**City of Portland, Maine - Building or Use Permit Application**  
 389 Congress Street, 04101 Tel: (207) 874-8703, Fax: (207) 874-8716

Permit No. 02-0260	Issue Date JUL 18 2002	CBL: 056 D005001
--------------------	------------------------	------------------

This is to certify that Macgregor-forbes Erin & /no contractor  
has permission to Build 7' x 24' Deck  
AT 36 Cushman St 056 D005001

Re: Rear Porch Construction

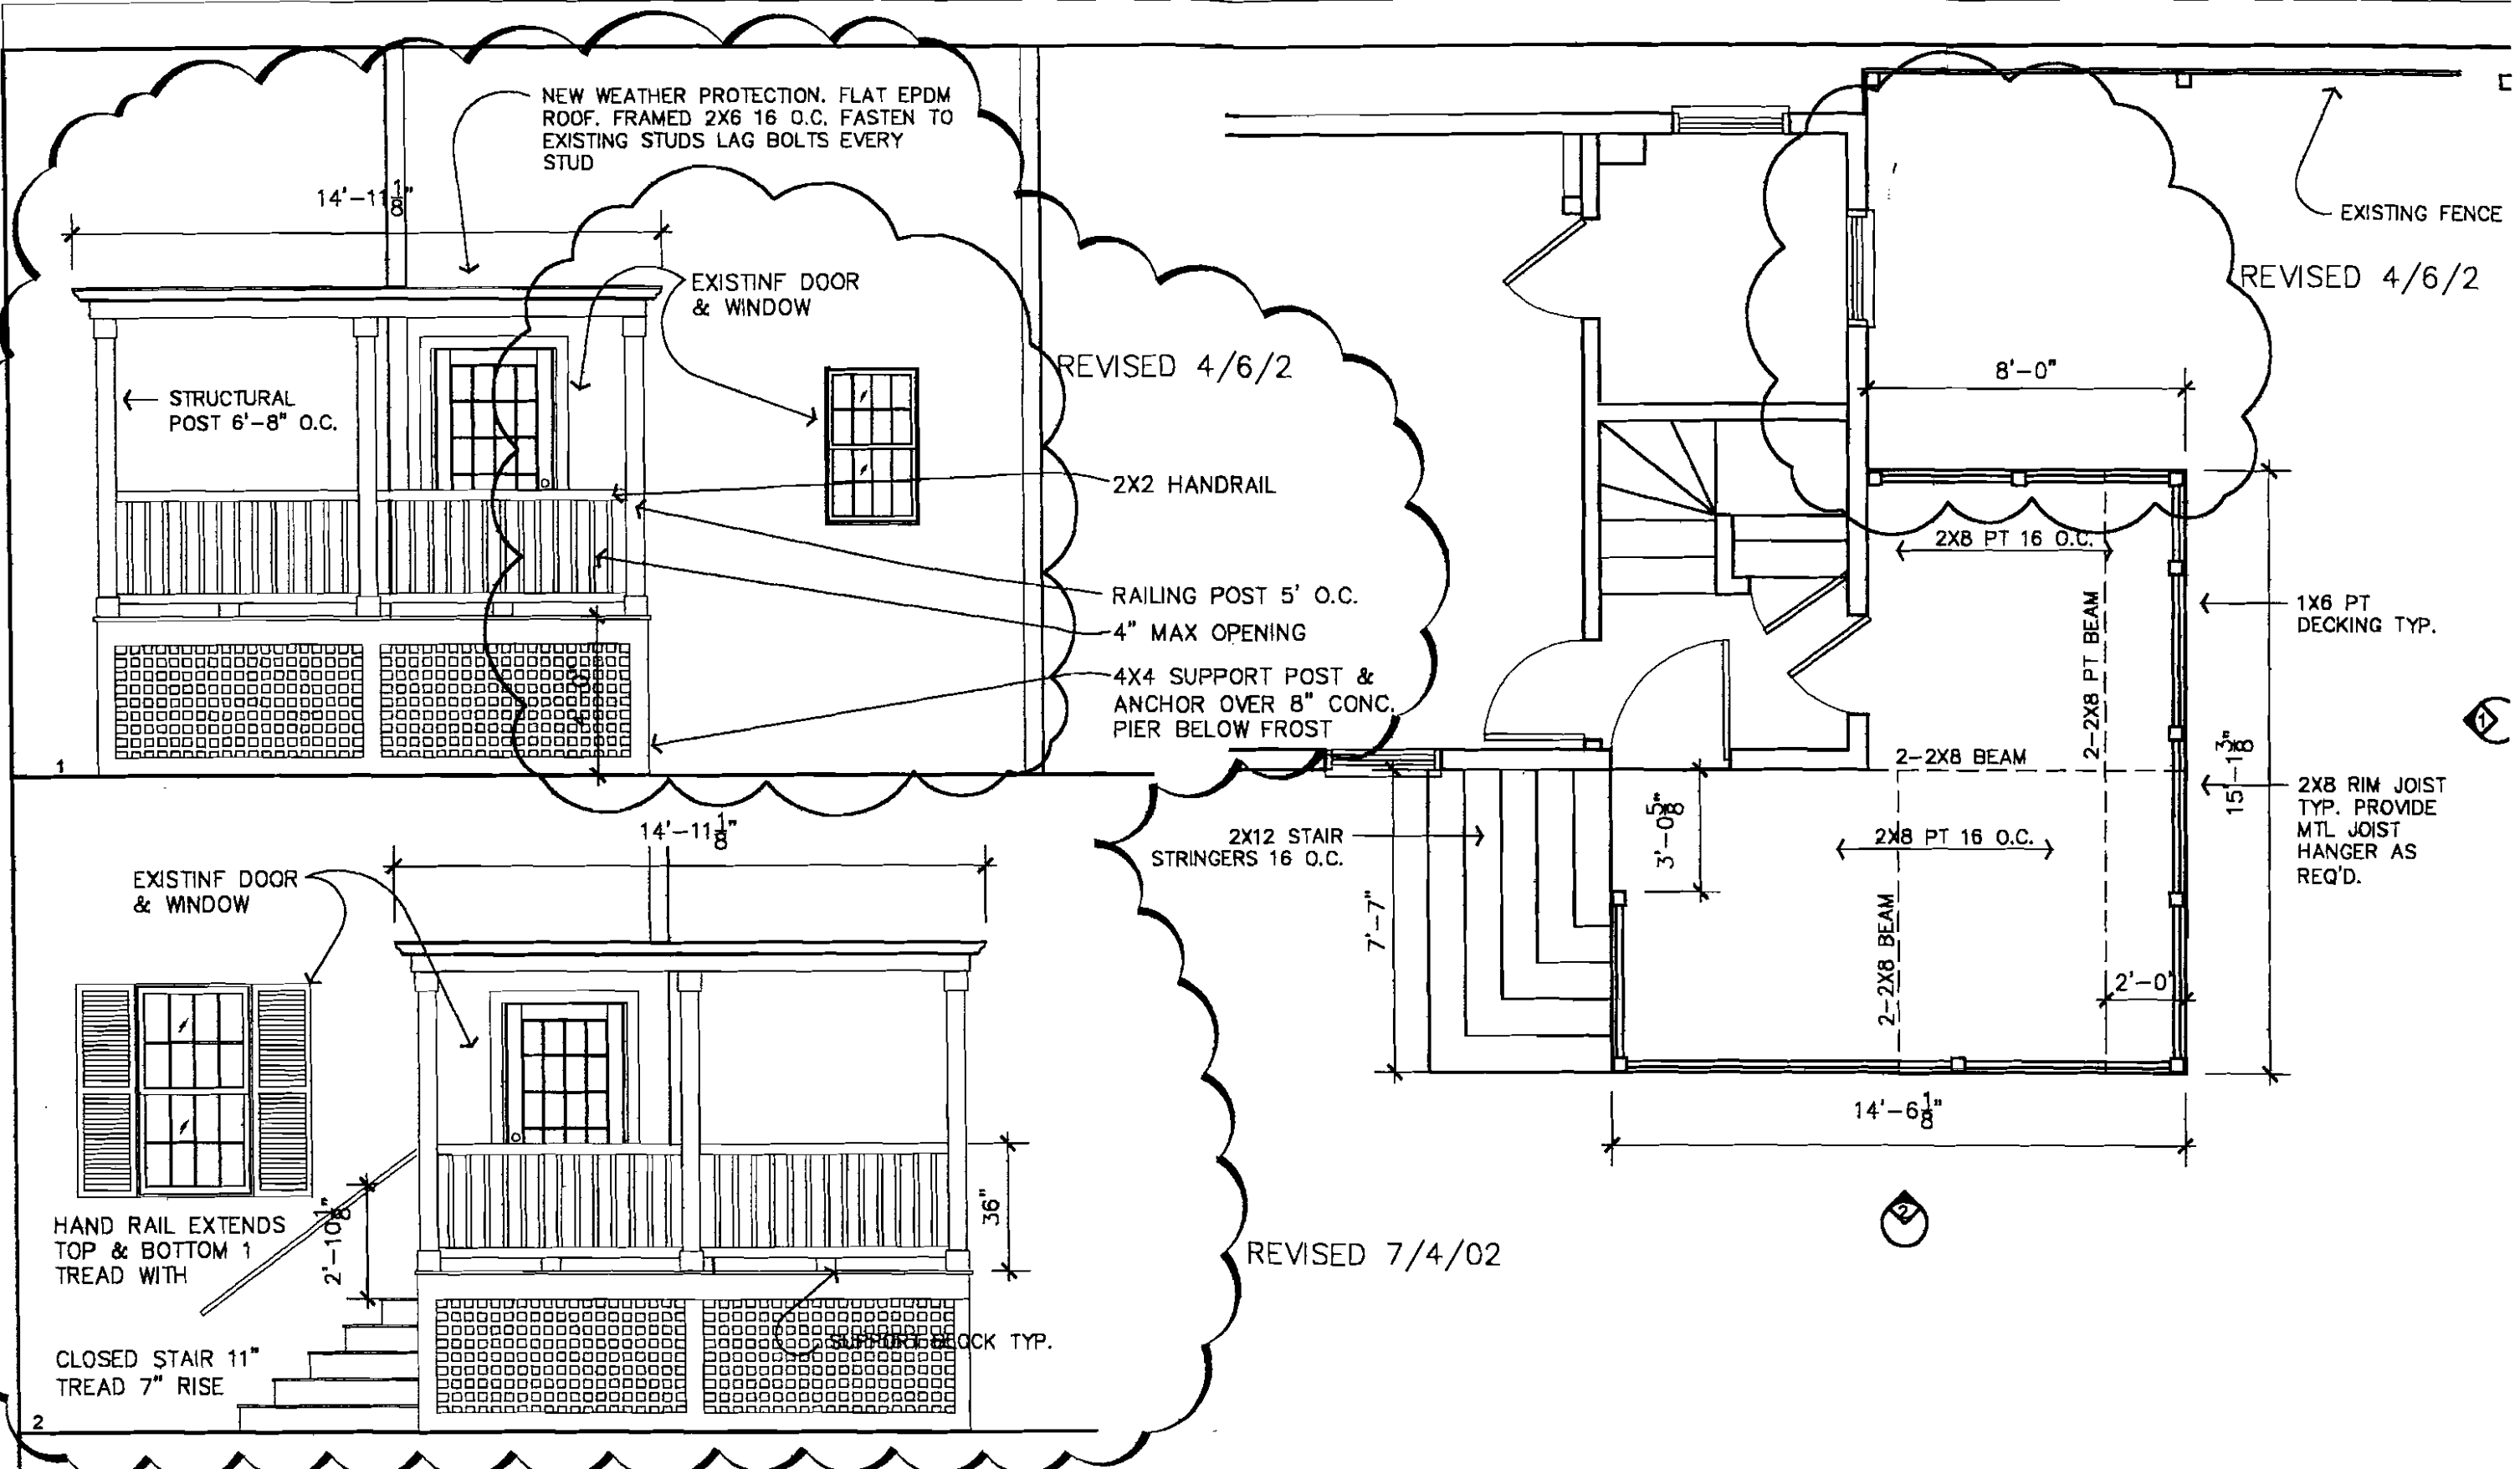
- Square balusters from 2" x 2" stock.
- Clearance between balusters not to exceed 3 1/2".
- Handrail to be chamfered.
- Porch posts (4"x4"?--no dimension given) to be dressed in pine with cap & base detail chamfered or trimmed with scotia molding
- Porch skirting to be fully framed with 3/4" square lattice panels.

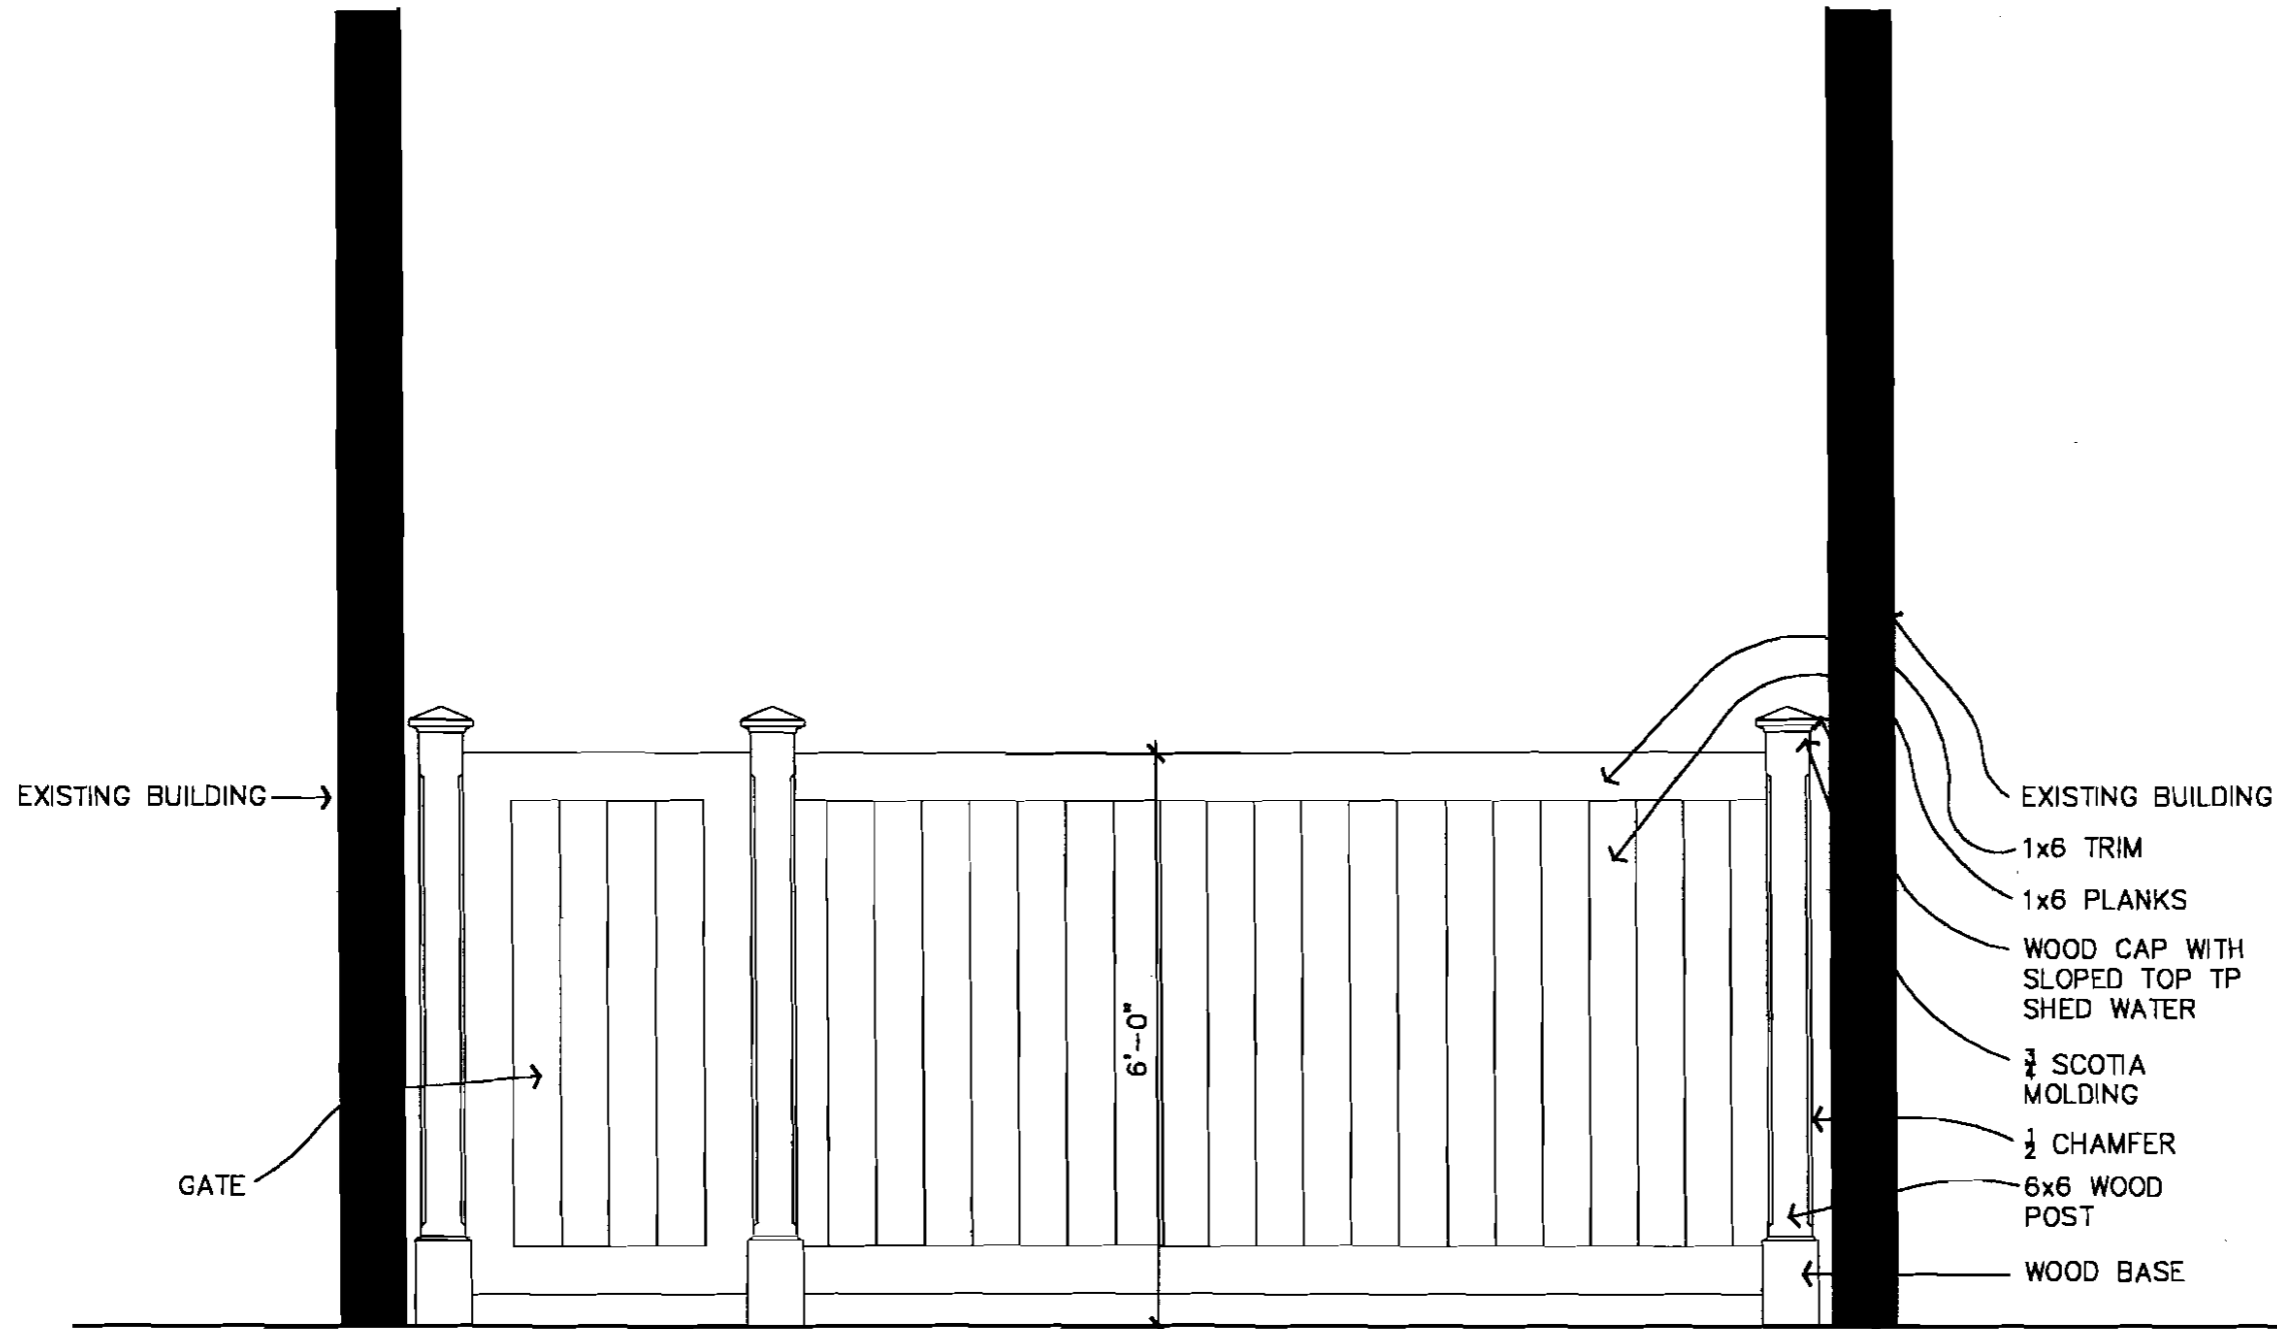
Comments: 4/3/02 - rear addition is only 1'1" from the side lot line instead of the 10' required (under some circumstances, may allow as close as 5', but not 1') left voice message to owner - will write letter.  
4/11/02 - Recieved revisions - setbacks ok
